Application Number: N6/2010/2055/MA

Comment: I wish to register an objection to both planning applications 2010/2055/MA and 2010/2060/LB for the redevelopment of the site on Broadwater Road.

Pedestrian and cycle access

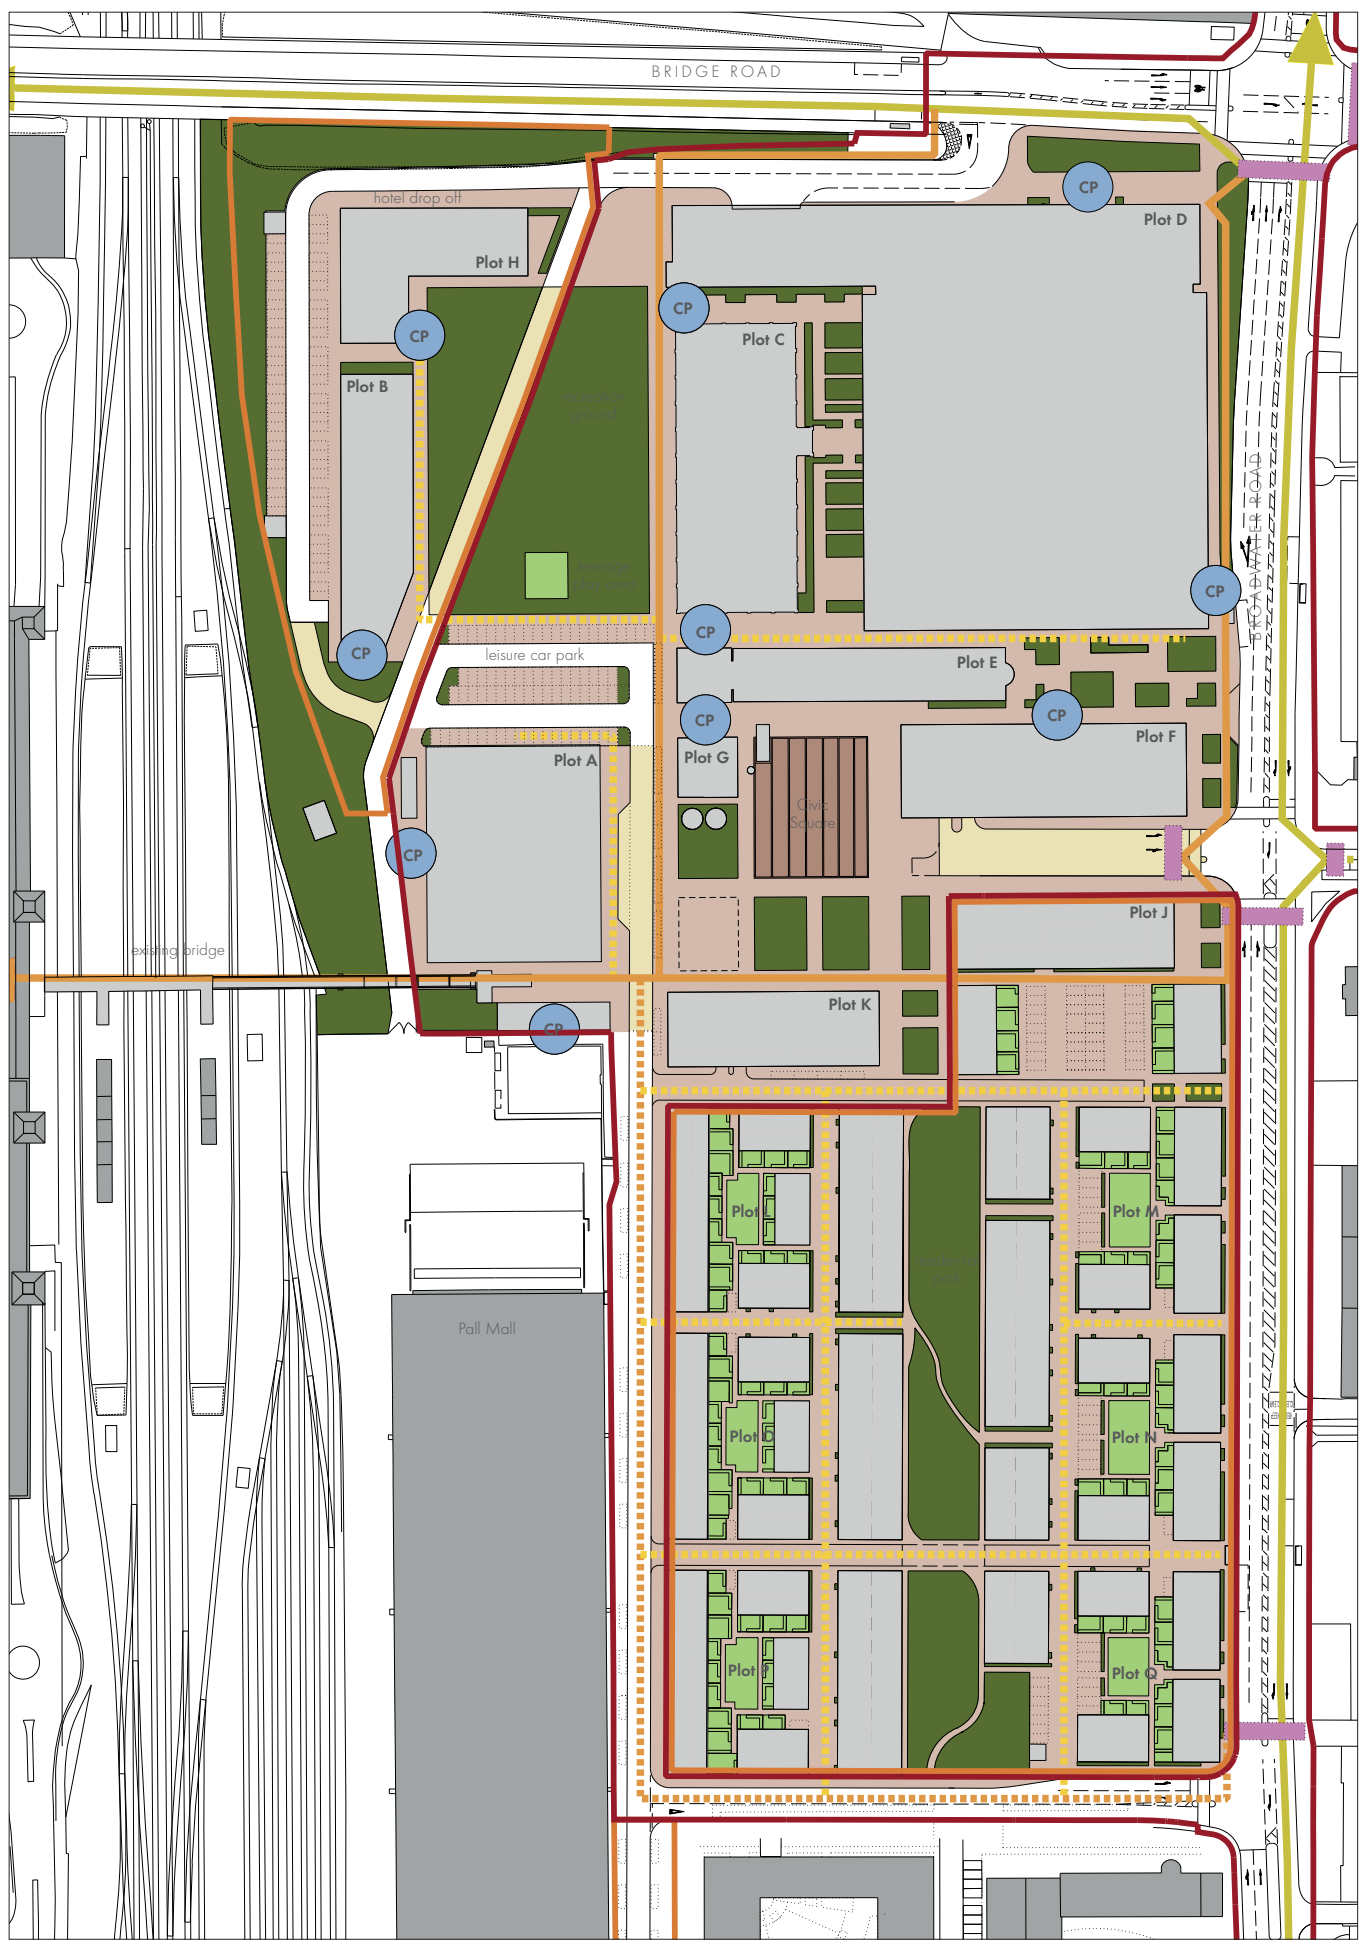
The main pedestrian route into the site appears to be between Plots F & J, this road also serves as the access and egress for all vehicles to the basement parking. The applicant has indicated within their proposal that pedestrian access will be a priority however this two uses would appear incompatible in this location due to potential volume of vehicular traffic.

Shared surfaces are proposed within residential roads however these should be avoided as there is

currently no suitable tactile paving recognised for this situation to ensure that disabled people, and in particular people with a visual impairments, are able to safely use and navigate through these schemes. There is significant research against this type of design from both Guide Dogs and the PAMELA research lab and no such scheme should be given permission until the research and conclusions on how to make these schemes inclusive to all have been drawn.

Shared pedestrian/cycle routes are proposed and as above these should be avoided as they cause difficulty for pedestrians and in particular disabled people and children.

02. BRIDGE LEVEL PLAN : PROPOSED

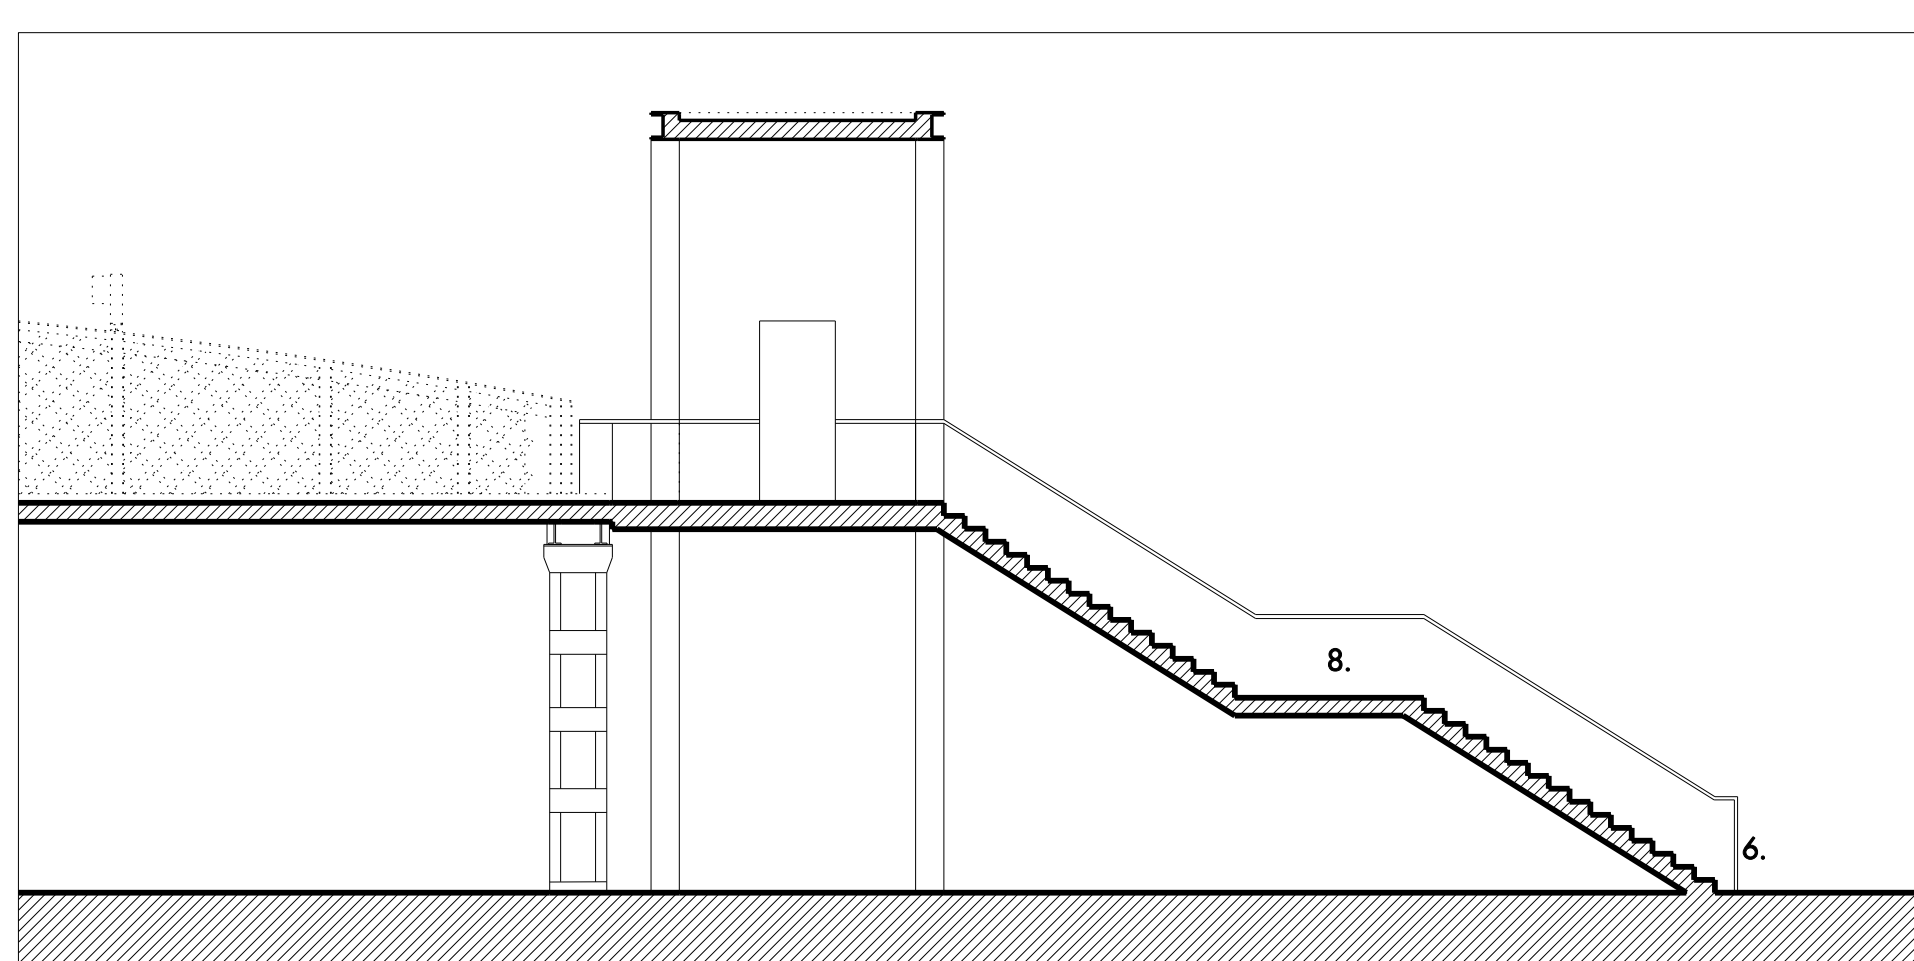
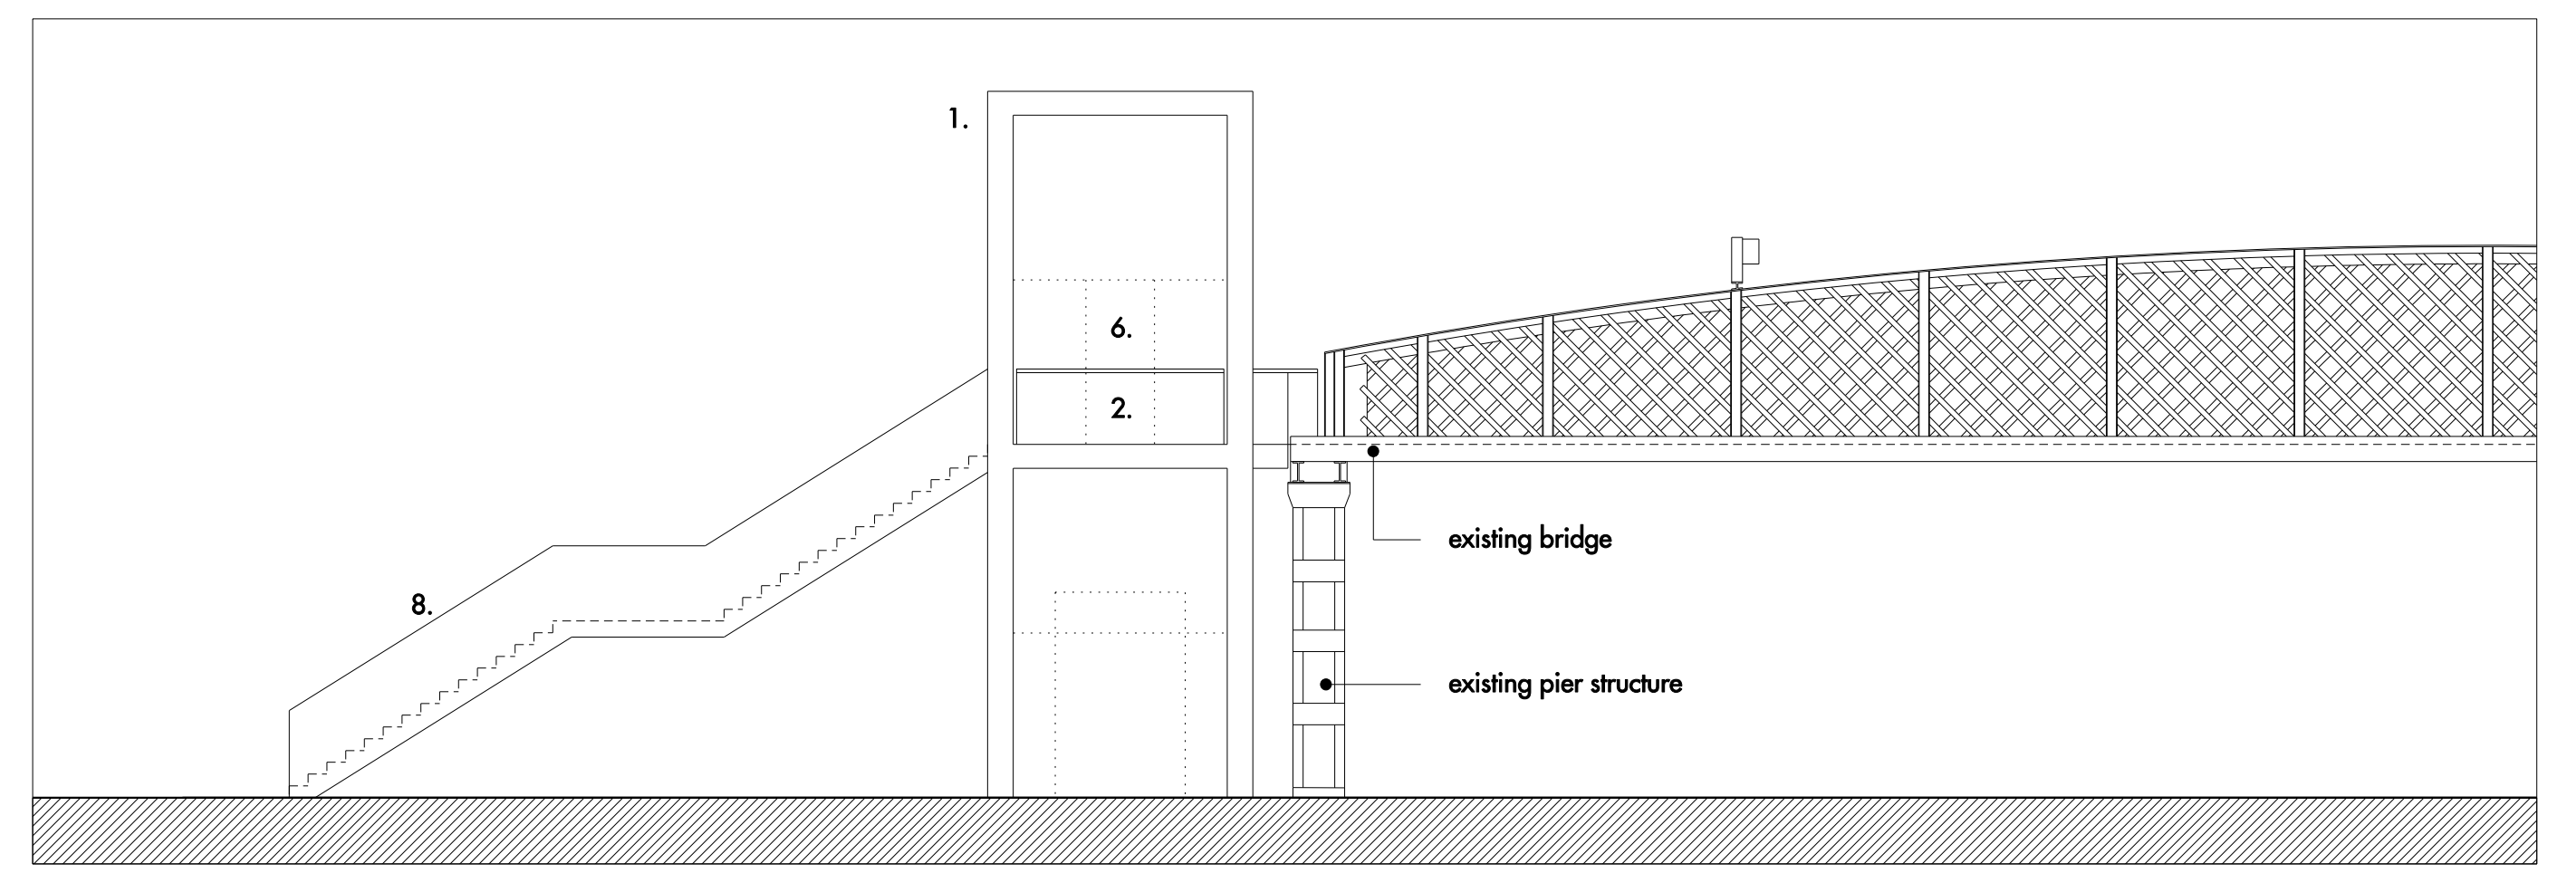
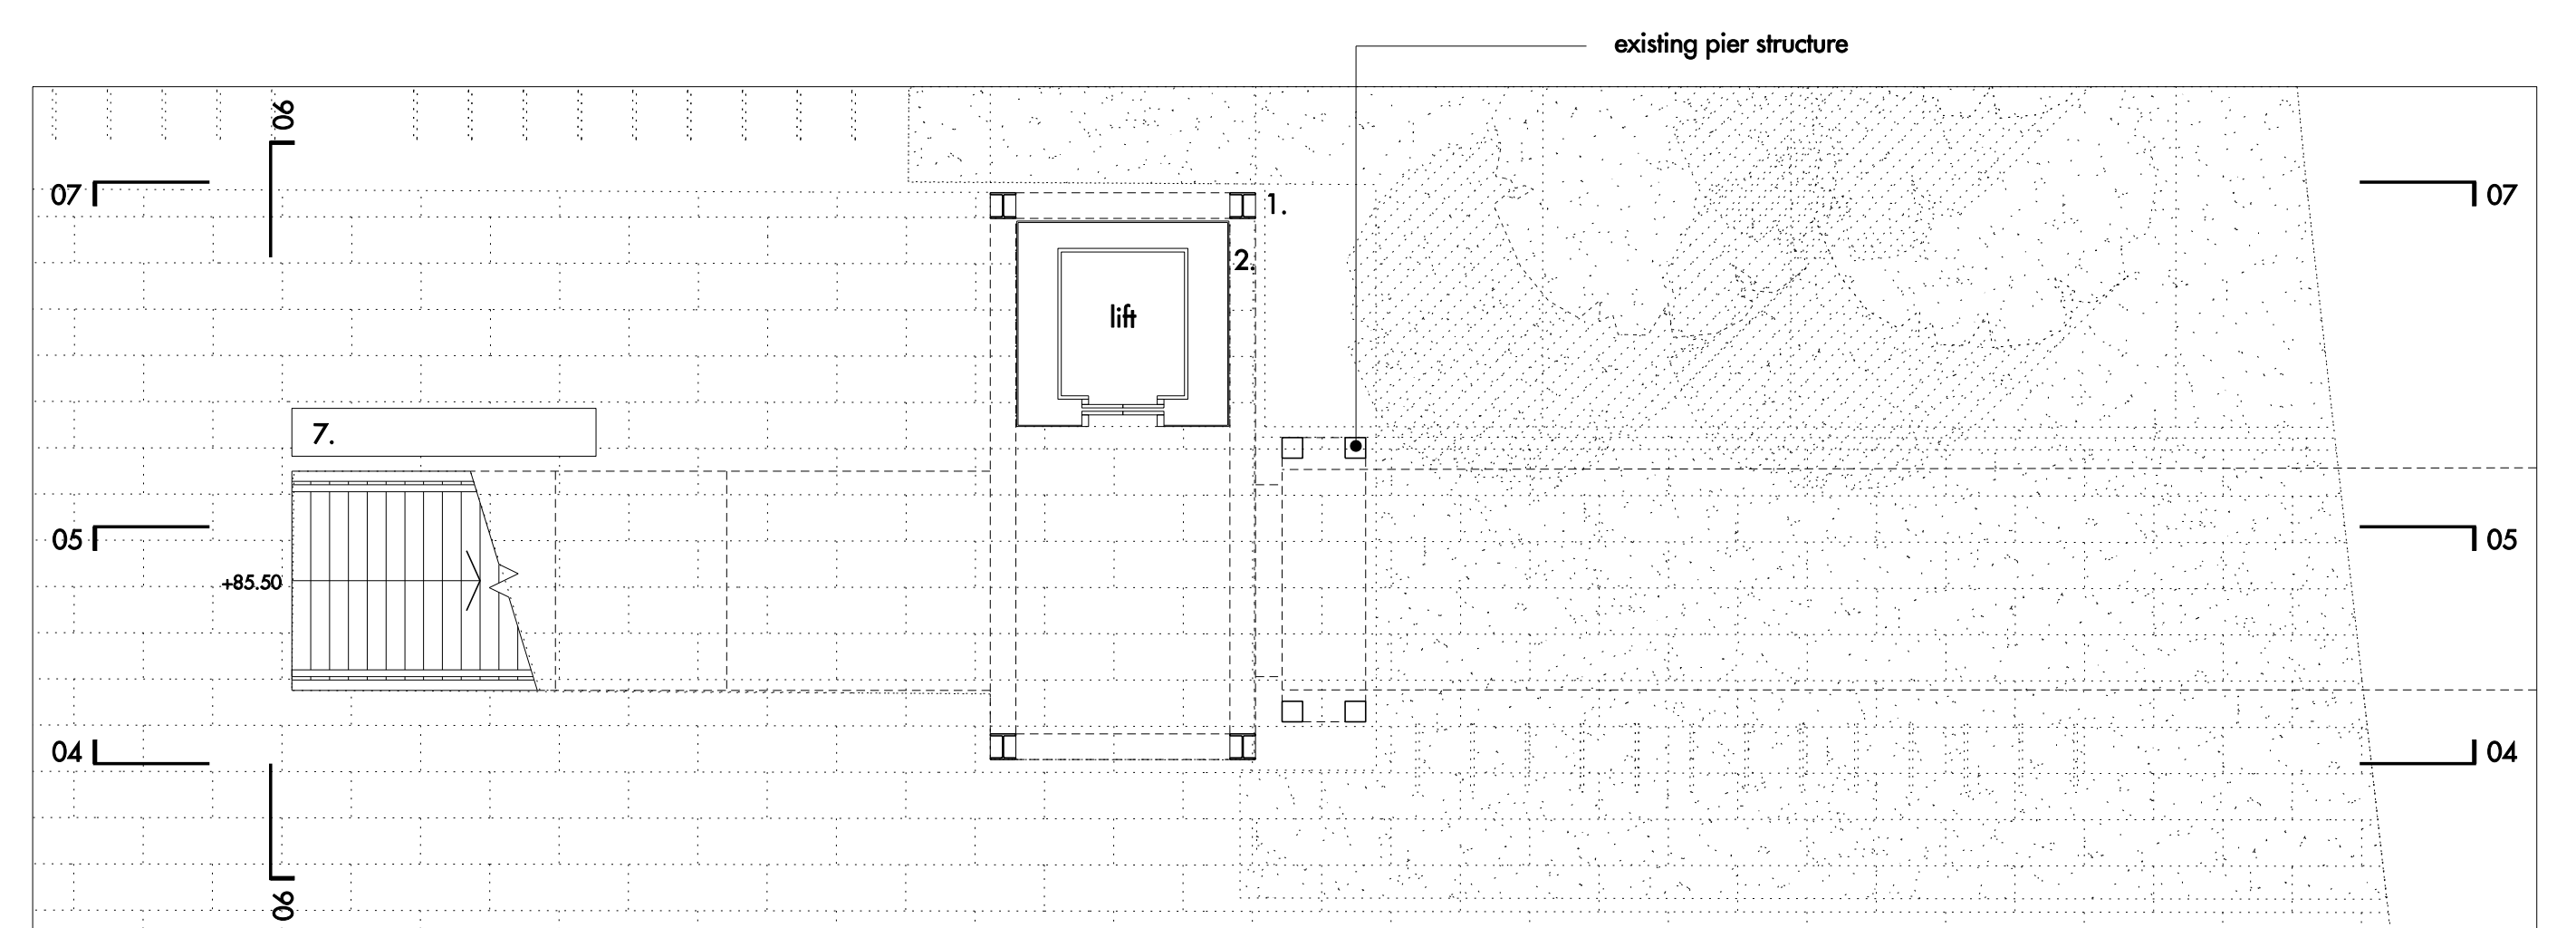
The application drawings indicate that the actual bridge is to be retained in its current condition with the narrowing bars remaining. Given the potential increase in pedestrian flows through this route this would not appear to be an acceptable solution or in line with the guidance in the SPG. The minimum clear pedestrian route that should be provided to enable 2 wheelchair users to comfortably pass each other is 1800mm wide (see BS8300:2009) and this should be required as a minimum. There are clearly already some structural issues with this bridge as its width was reduced 5+ years ago so it cannot be considered a suitable structure to provide adequate pedestrian access to the town centre.

The drawings also indicate a lift to be added to the structure however this does not contain a 1500 x 1500mm clear landing space at the upper level of the pedestrian route and should therefore be redesigned to ensure it meets current guidance.
